From: Dawn Grocock [Dawn.Grocock@hertfordshire.gov.uk]
Sent: 10 July 2015 14:24
To: Mark Peacock
Subject: RE: Consultation Invite: Land to the north east of King George V Playing Fields, Northaw Road East - PP-04267588 {-14644-0-}
Attachments: Possible New Path & ROWIP Details Plan.bmp
Categories: Printed by Planning Support

Application ID: S6/2015/1342/PP - Mr M Peacock Application Owner: Welwyn & Hatfield Borough Council(Development Management Officer)
Applicant: Marrons Planning
Location: Land to the north east of King George V Playing Fields, Northaw Road East - PP-04267588 Deadline Date: 24/07/2015 00:00:00
Description: Outline Planning Application for residential development of up to 121 dwellings, associated infrastructure and a change of use from agricultural land to an extension of the King George V playing field

Drawing file: 141386_A_51 Rev A - Prop Shared Cycleway-Footway Link_South Drive-A_51.pdf

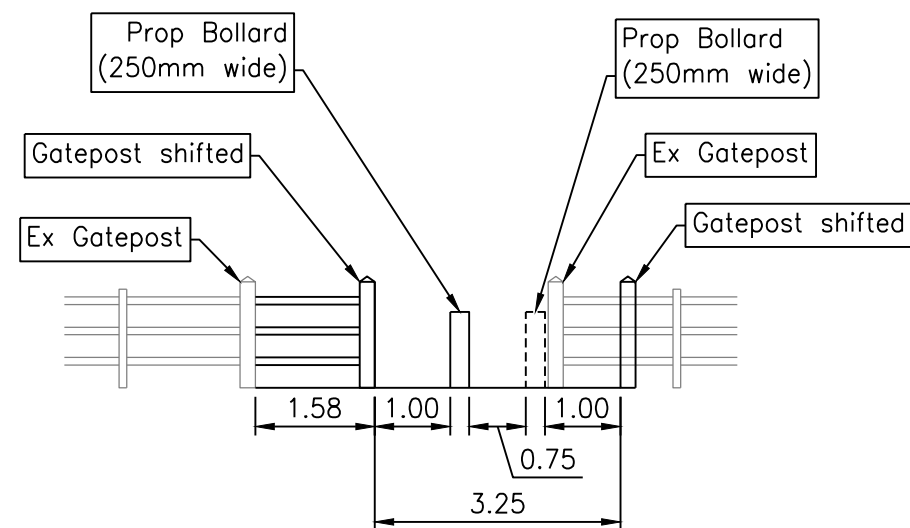
There is the possibility of local walkers submitting an application to record a path that was previously used between footpath 6 and South Drive, plan attached. Therefore including this route and dedicating it as a public right of way is wise. However, if they are looking for cycle use on this route as well, then it would need to be dedicated as a public bridleway, so it appears on the Definitive Map. Otherwise if they wish to only have a cycleway, then this can be discussed with Hertfordshire Highways. As with a bridleway, though this route would need to link to road or public right of way of the same or higher status, rather than public footpath 6.
